# **KITITAS COUNTY**

### **MEMORANDUM**

TO: All Staff  
FROM: Justin Turnbull, County Surveyor   
DATE: March 9, 2021  
SUBJECT: County Survey Review of BL-20-00029 Brain/Taneum Crk

PART OF THE NORTH HALF OF SECTION 1, TOWNSHIP 18 NORTH, RANGE 16 EAST, W.M.

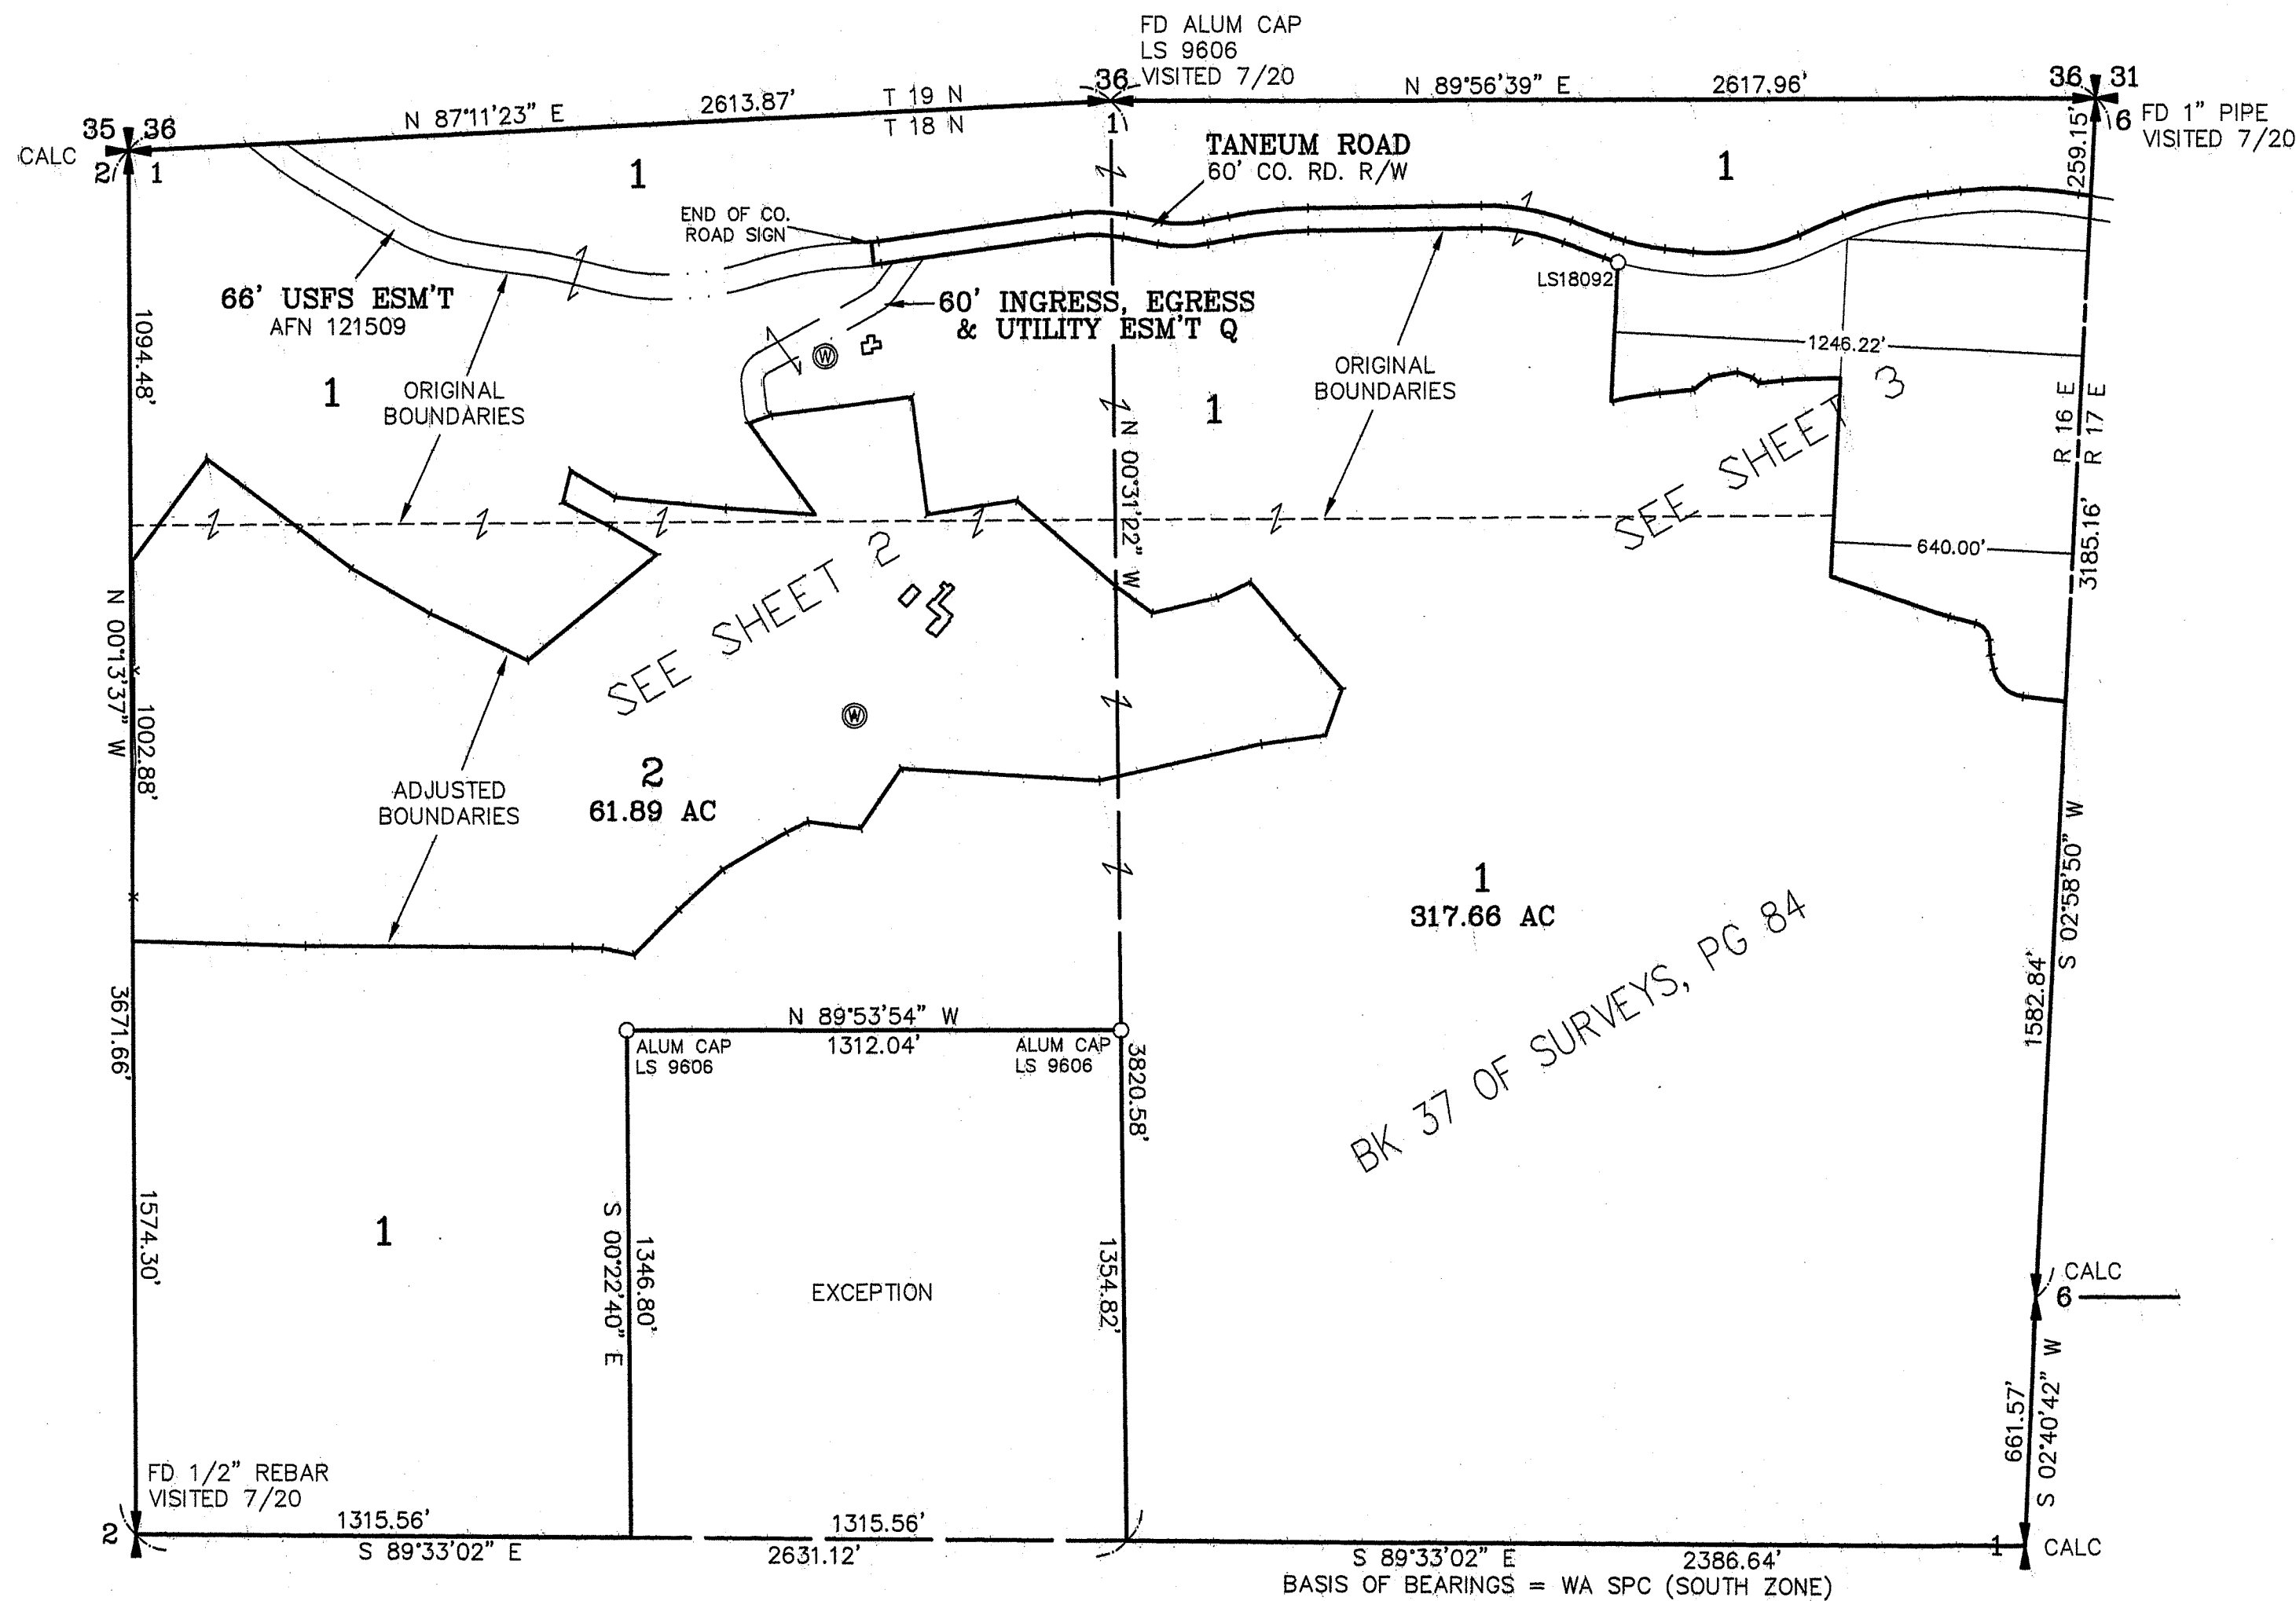
1. Include a note detailing the purpose of survey, together with an application number.
2. Please include the specific surveys utilized in Note 3, as some surveys of record show varying positions. If any portion was determined by field observations, please note this as well.
